Rolling Meadows Substation
Construction of a New Electrical Substation
including Grading, Drainage, and Surface Improvements
El Paso County, Colorado

PPR2619

EPC STORMWATER REVIEW COMMENTS
IN ORANGE BOXES WITH BLACK TEXT

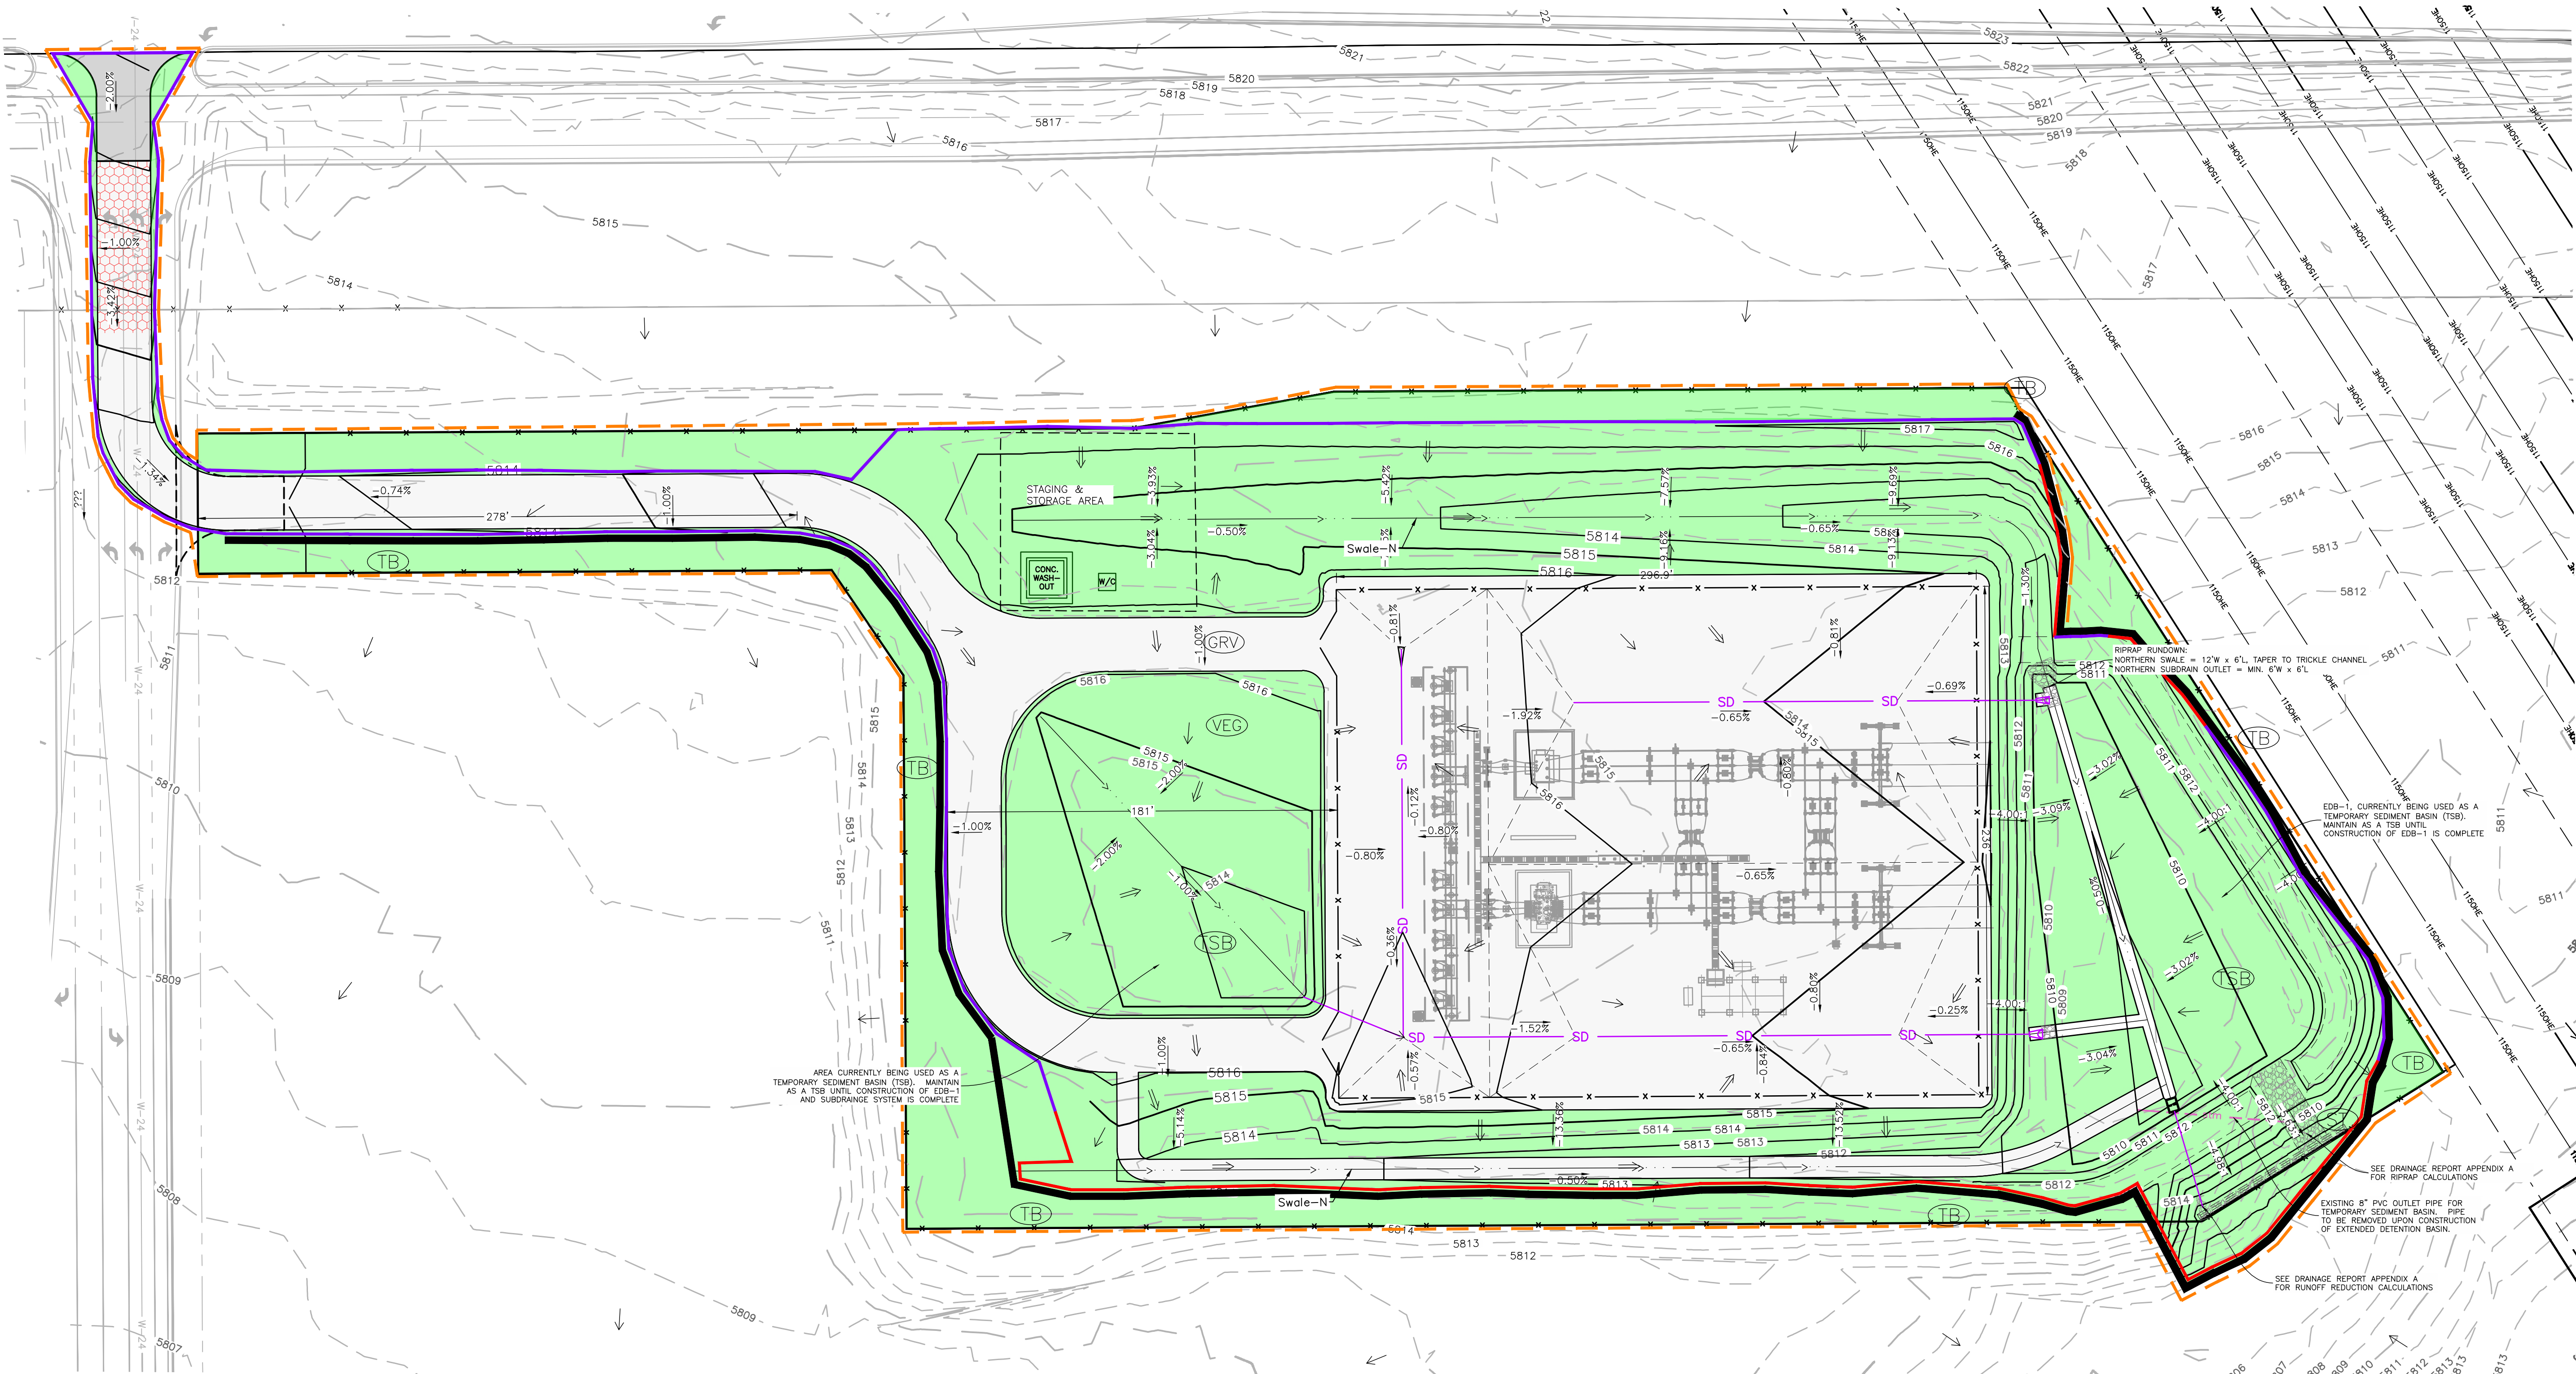
GEC Checklist Item X - Provide details for these BMPs even if they were installed by others. If maintenance on them is needed during construction having the details for them would be needed.

Silt fence to be included in the LOC/LOD

The haul road, borrow pit, and other disturbed areas associated with the early grading activities will need to be re-vegetated. Also the two additional TSBs will need to be removed. These areas appear to be outside of the PPR's disturbance limits so will those areas be restored by the EGP permit holder? If that reveg/BMP removal will be done under the PPR include on these sheets.

Per the EGP253, this is a TSB currently. I'm assuming this will be maintained as a TSB through the initial/interim phase. Is this correct?

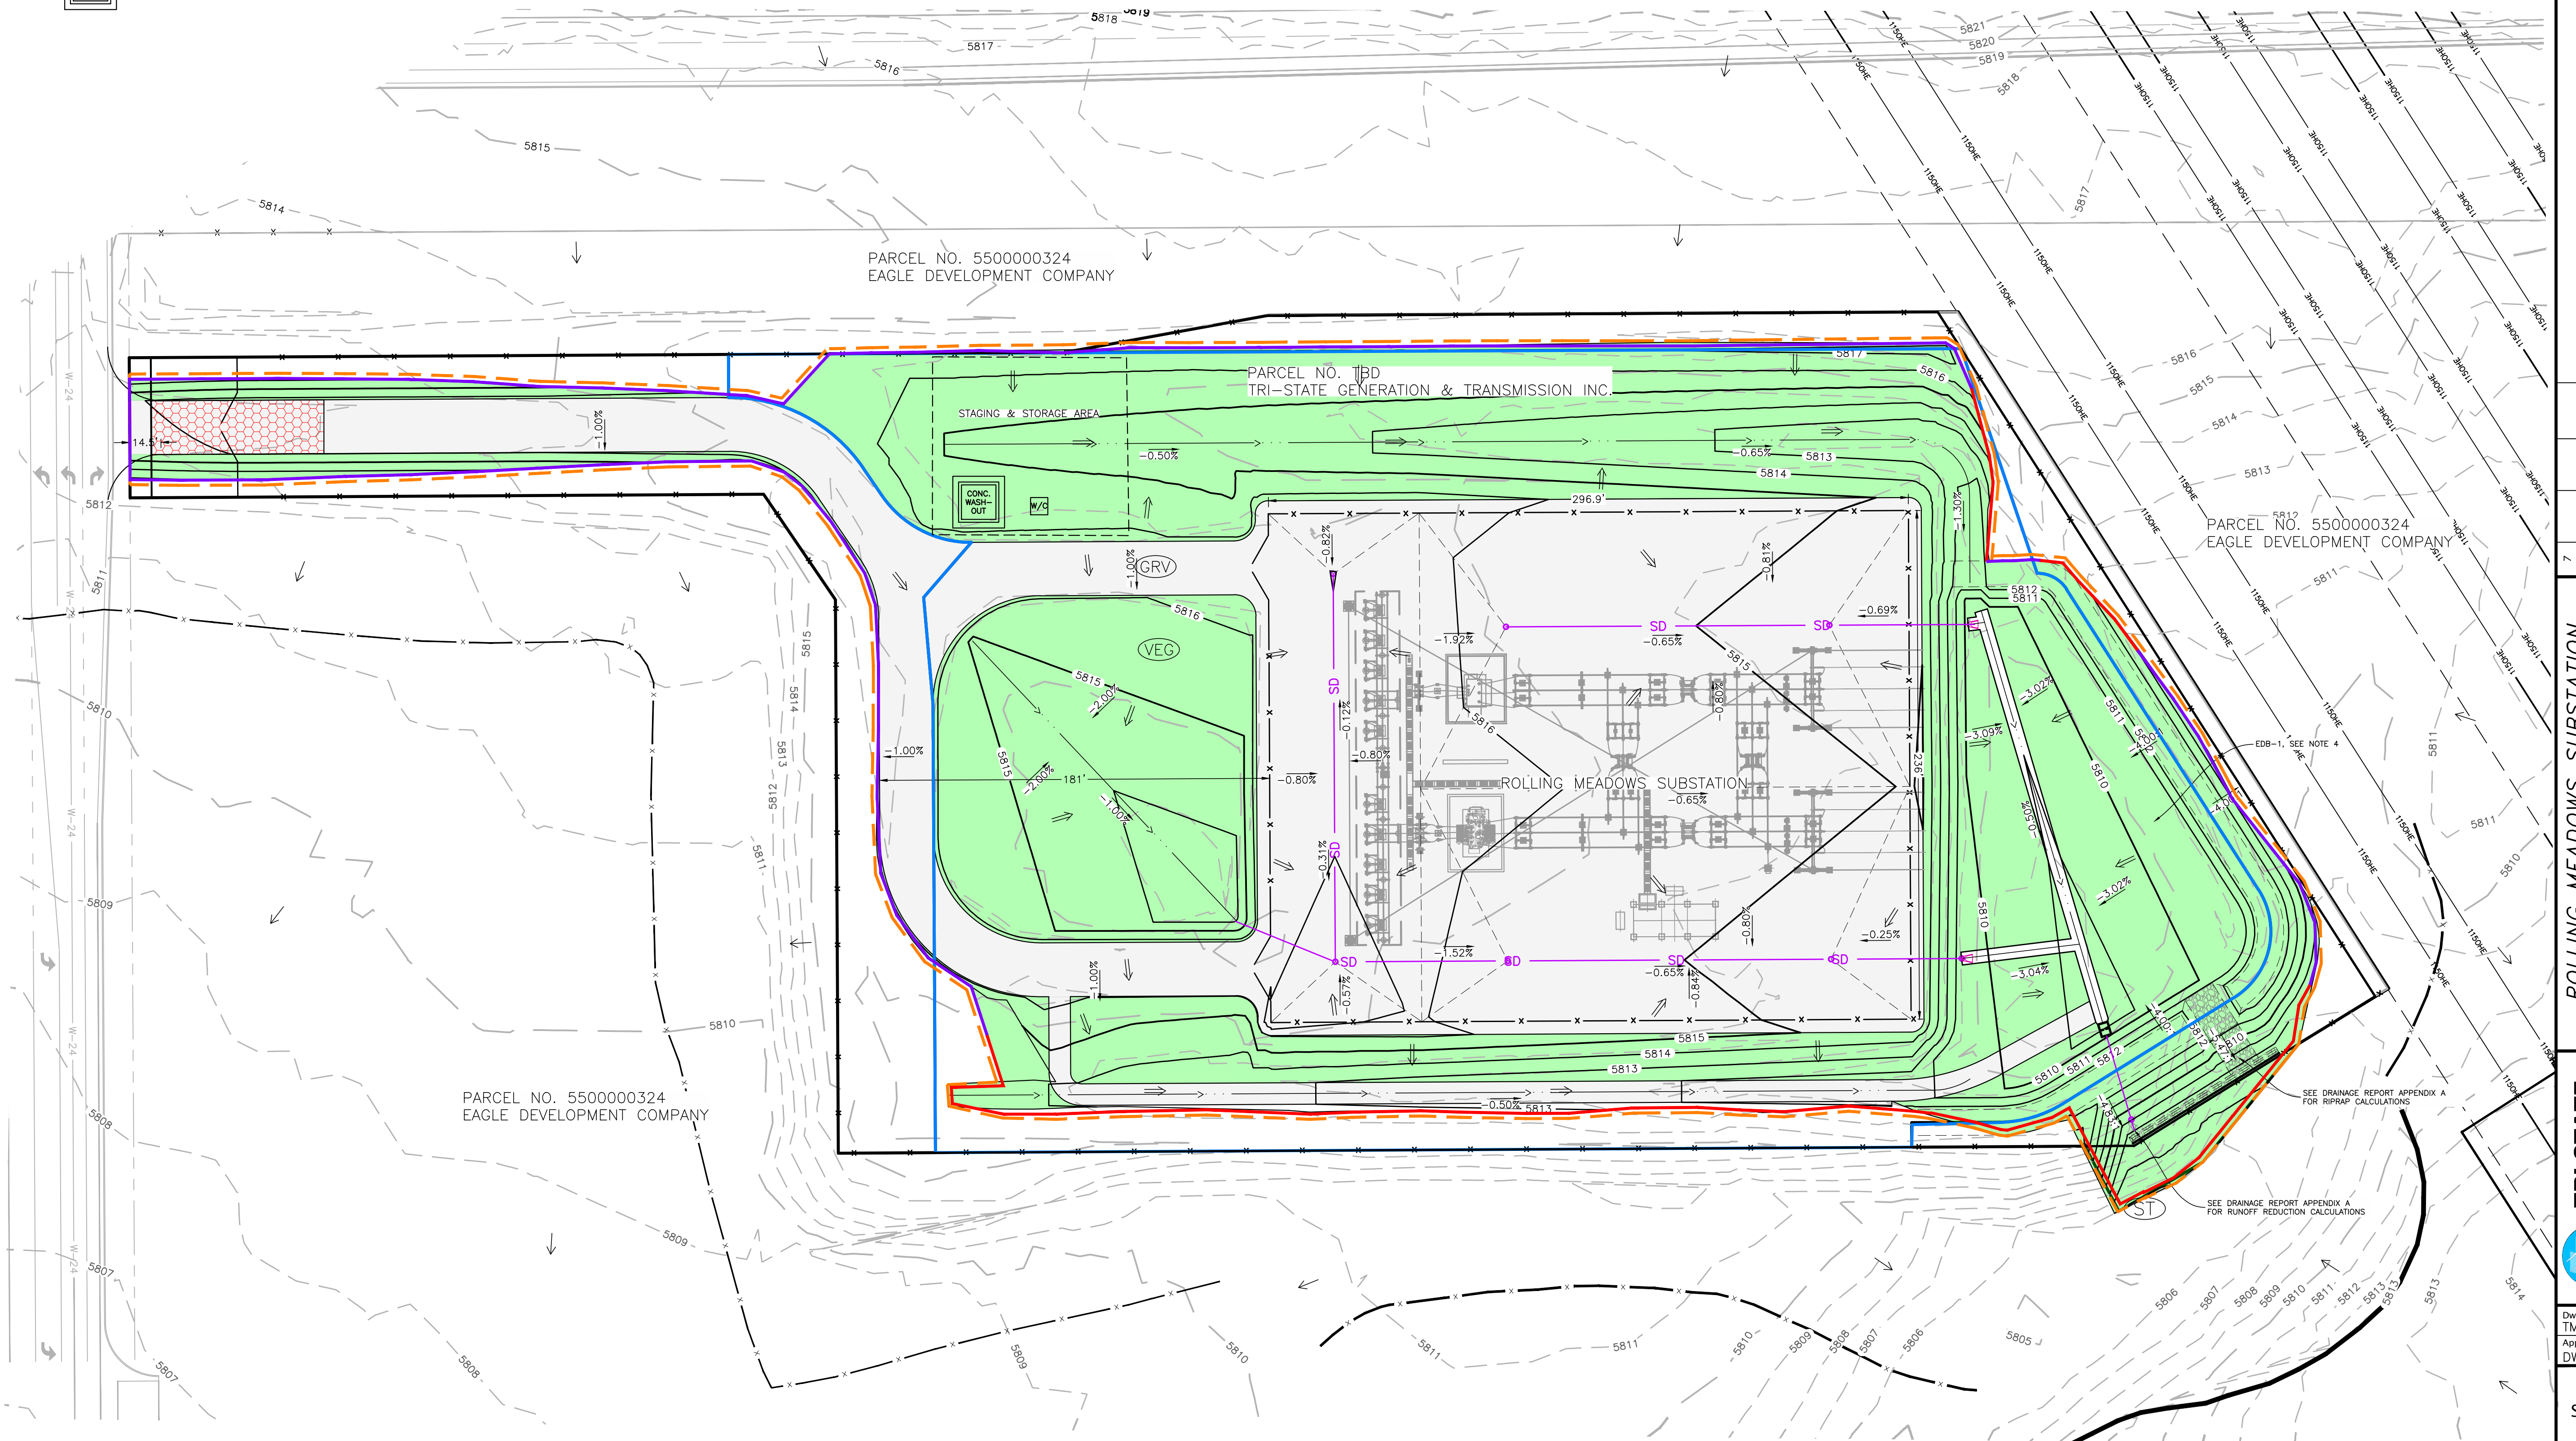
Label roads, include road classifications & ROW widths

Add contour labels

Label slopes

Ensure design calculations are provided for both swales

Label cleanouts and area inlets

Label HP where flows split

Provide slopes

Add additional contour labels in this area

Provide riprap rundown from end of swale to pond forebay

Label level spreader
